CITY OF PORTLAND, MAINE

PLANNING BOARD

May 1, 2018

Project Name: Building Conversion
Address: 415 Cumberland Ave.
Applicant: Sam Reiche
Planner: Christian Roadman

**A2.01**

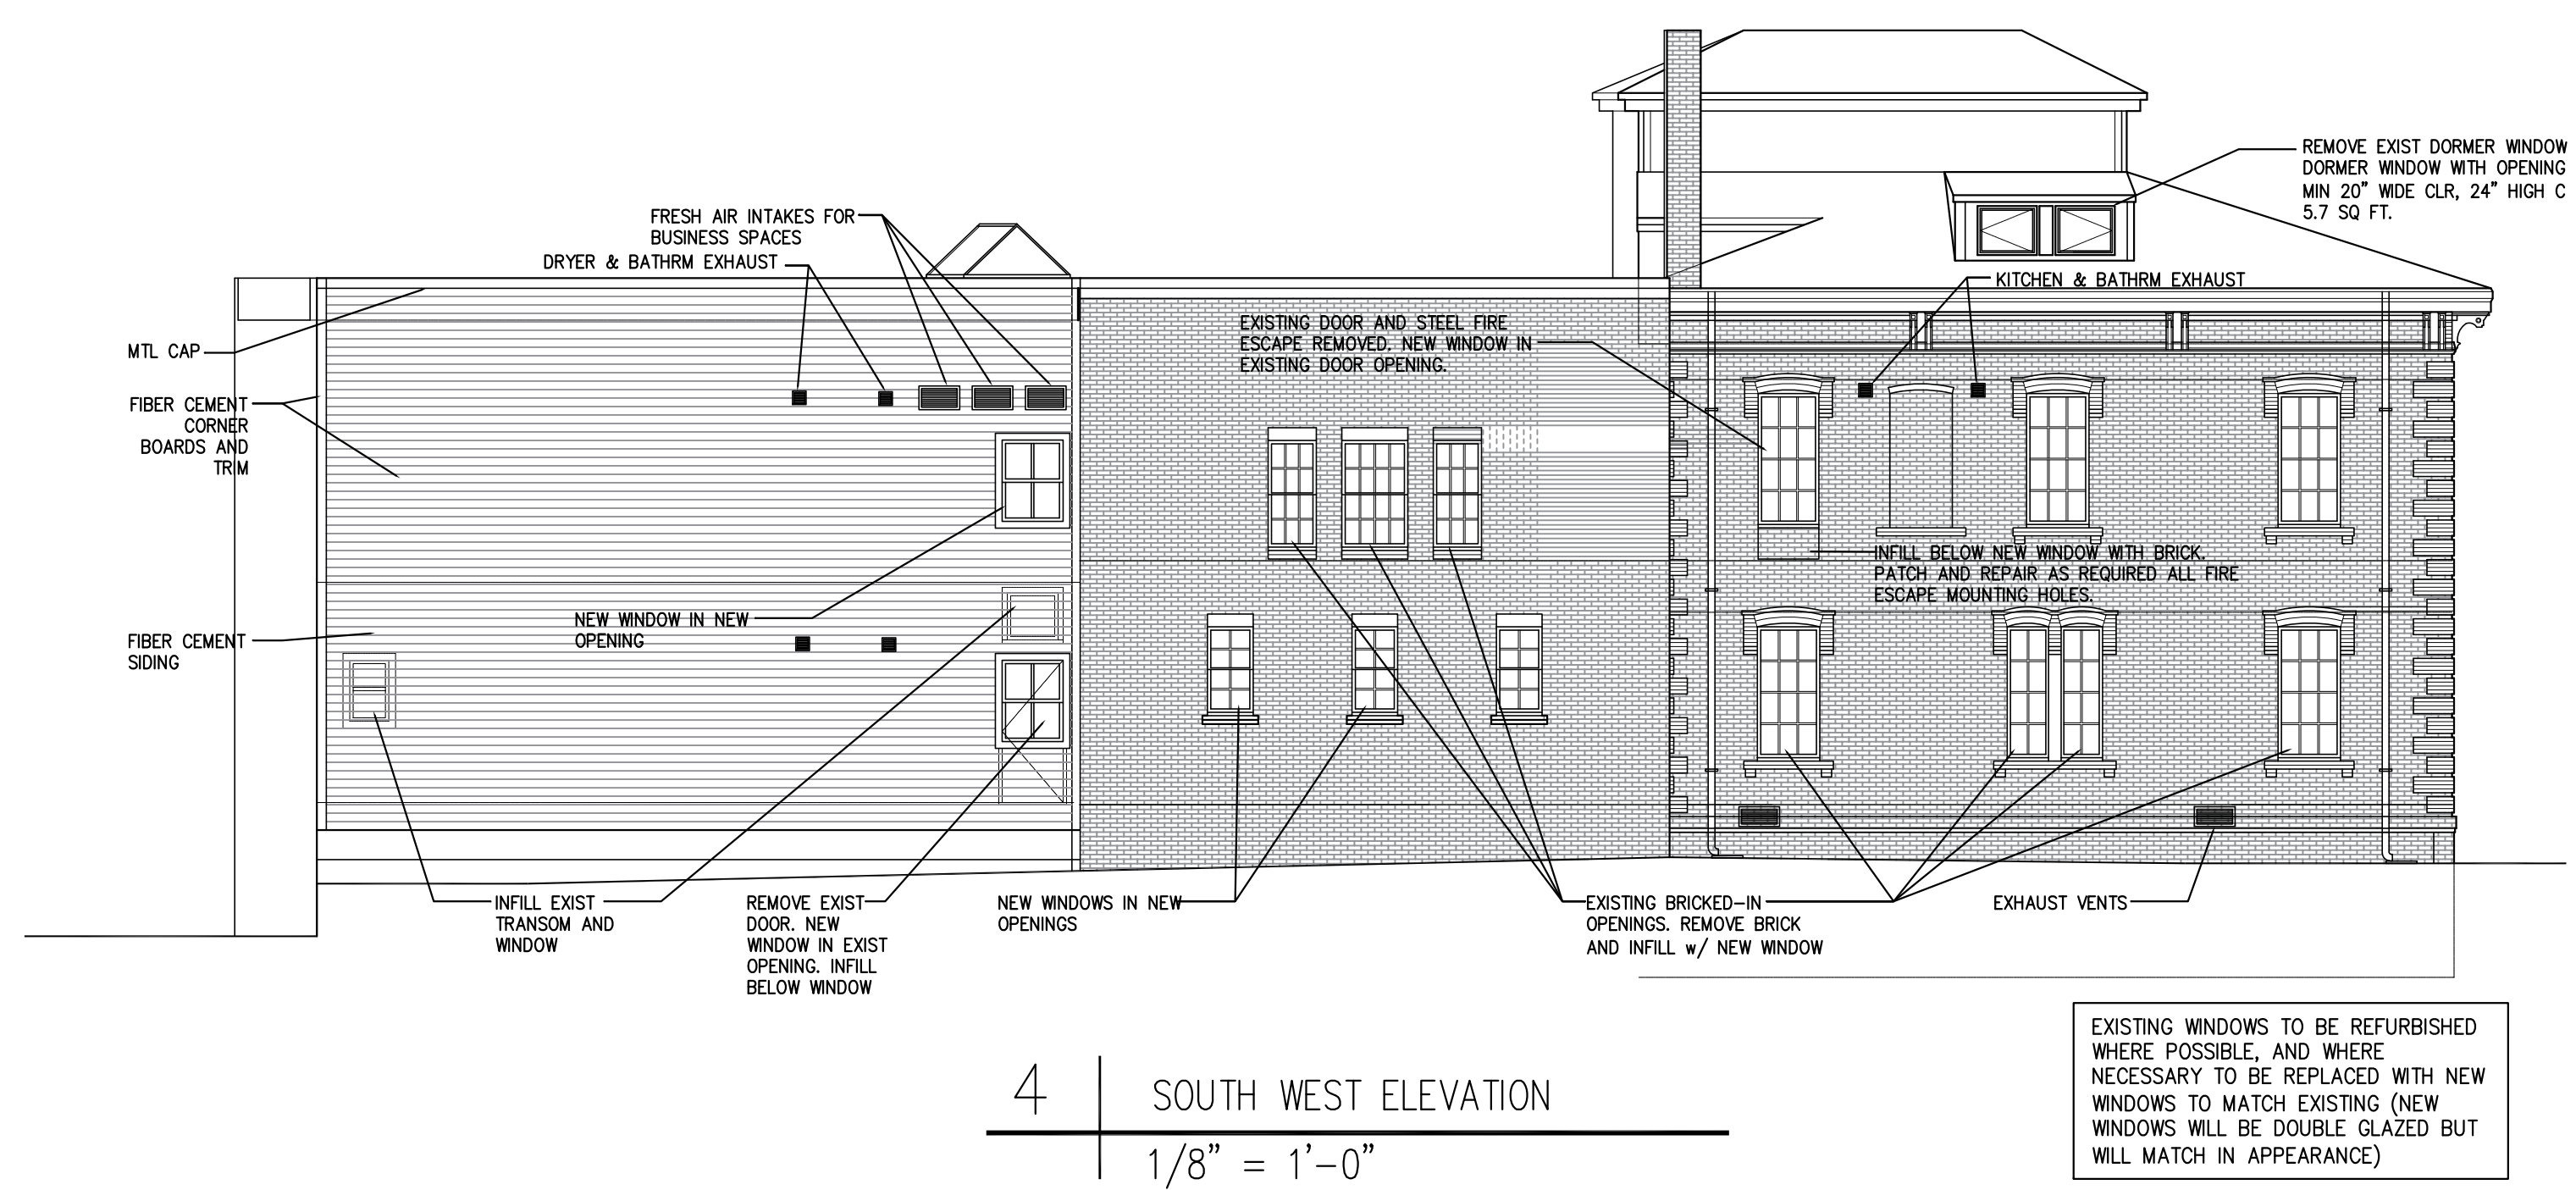
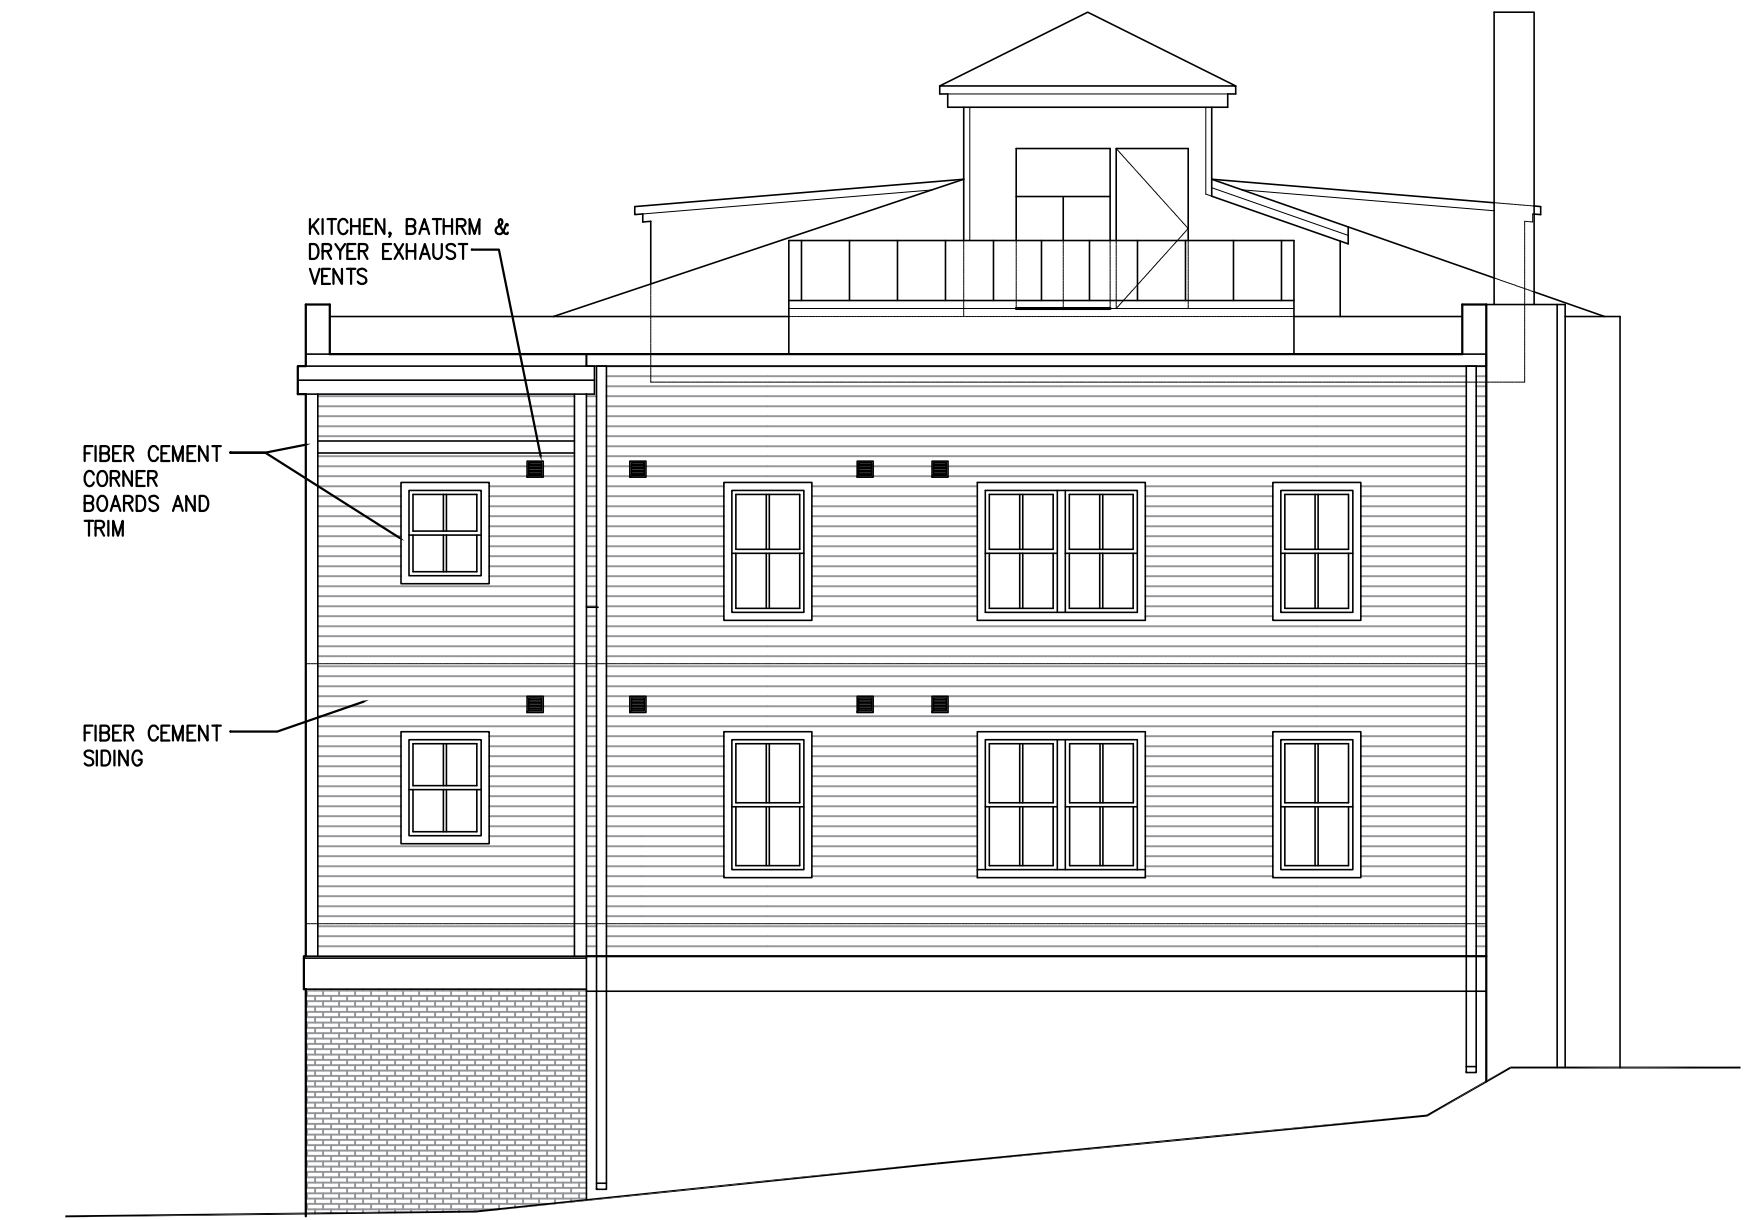
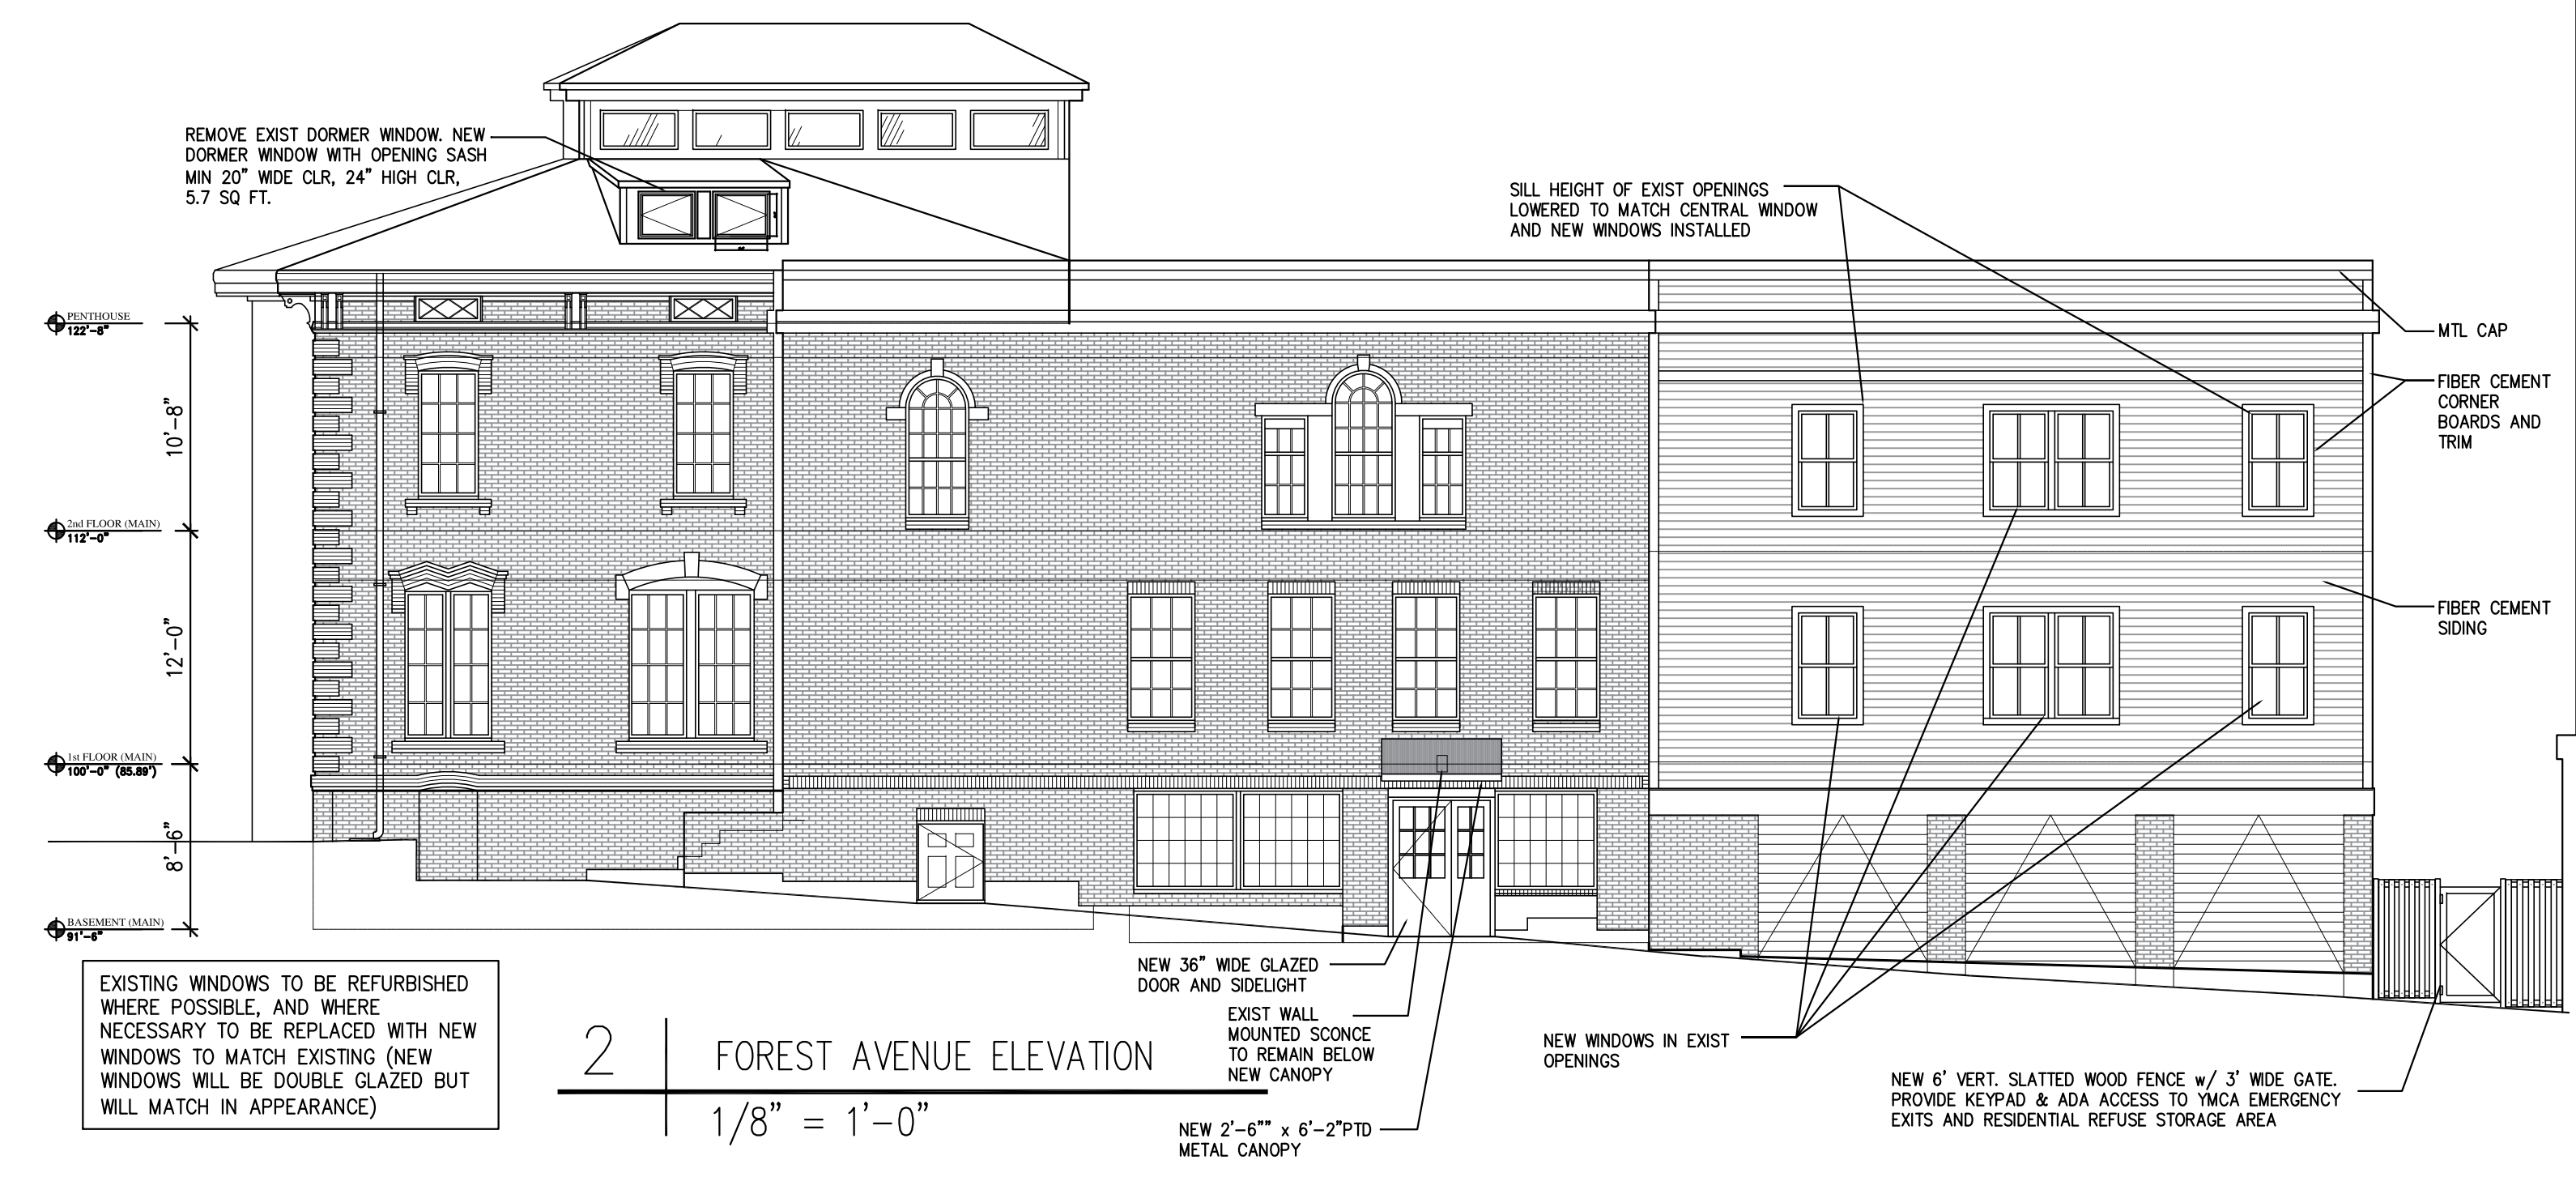
Ms. Andrews commented that new windows should match the existing windows in material, muntin configuration and profile, color, and operation. This is of particular importance on elevations in which new and existing windows will be present.

Additionally, Ms. Andrews requested a detail of the metal canopy proposed over the Forest Avenue entrance. Proposed window details, as well as the proposed metal canopy detail, should be submitted for review and approval by Ms. Andrews as a condition of approval.

1. Proposed window specifications and the proposed metal canopy detail shall be submitted for review and approval by historic preservation staff.
2. The applicant shall submit additional information pertaining to construction management, including:
 - Pedestrian detour plan minimizing sidewalk impact; construction material delivery and truck plan minimizing sidewalk and vehicle lane impact; and, information on contractor parking such that public on-street parking is not impacted.
